WEST SUSSEX COUNTY COUNCIL CONSULTATION

TO:	Arun District Council
FROM:	WSCC - Highways Authority
DATE:	16 February 2022
LOCATION:	Morelands Arundel Road Arundel BN18 0SB
SUBJECT:	WA/5/22/PL Demolition of 1 No dwelling & erection of 5 No dwellings with associated car parking and access. This site is in CIL Zone 2 and is CIL Liable as new dwellings.
DATE OF SITE VISIT:	n/a
RECOMMENDATION:	More Information
S106 CONTRIBUTION TOTAL:	n/a

Drawing Number	11636/2200	Rev.	P5
----------------	------------	------	----

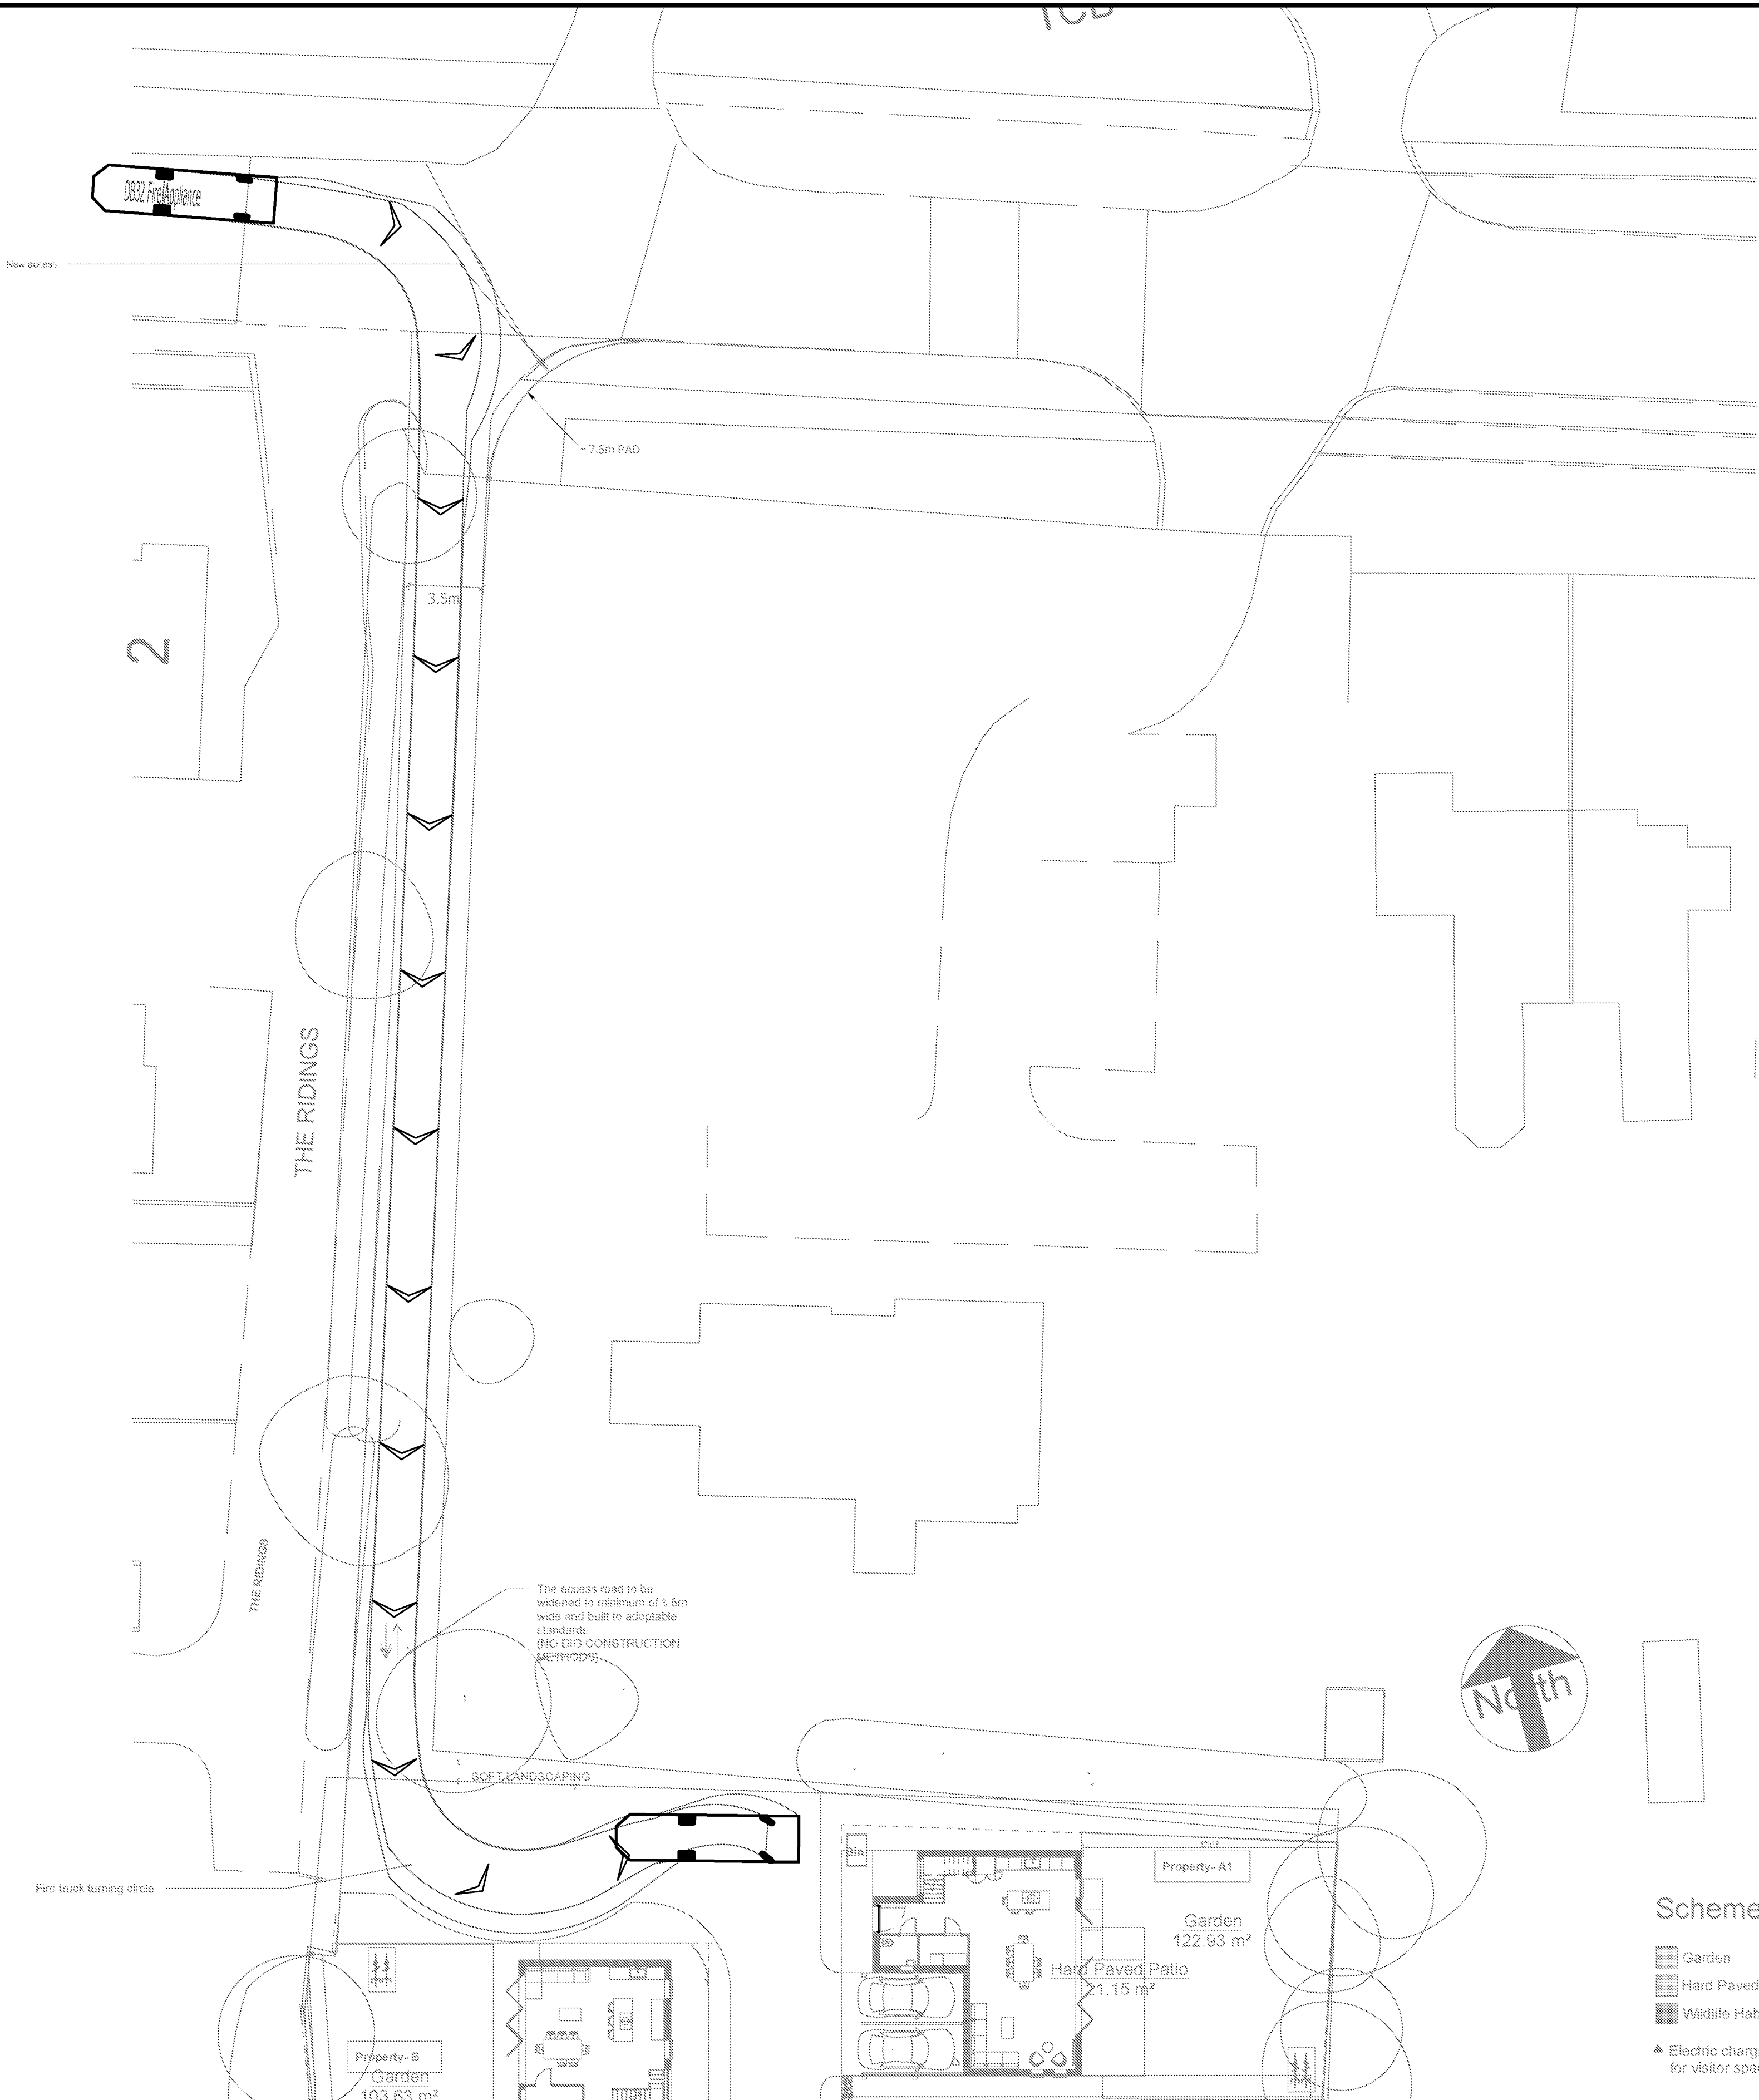
1. As part of the Section 278 works required to create a bellmouth, the applicant needs to provide at planning, the location of tactile paving where the footway crosses the proposed junction.
2. The applicant and the LPA are advised to FRSWaterandAccess@westsussex.gov.uk regarding the tracking provided for Fire Access.
3. The applicant is advised to ensure all parking provisions are to Arun Standards.
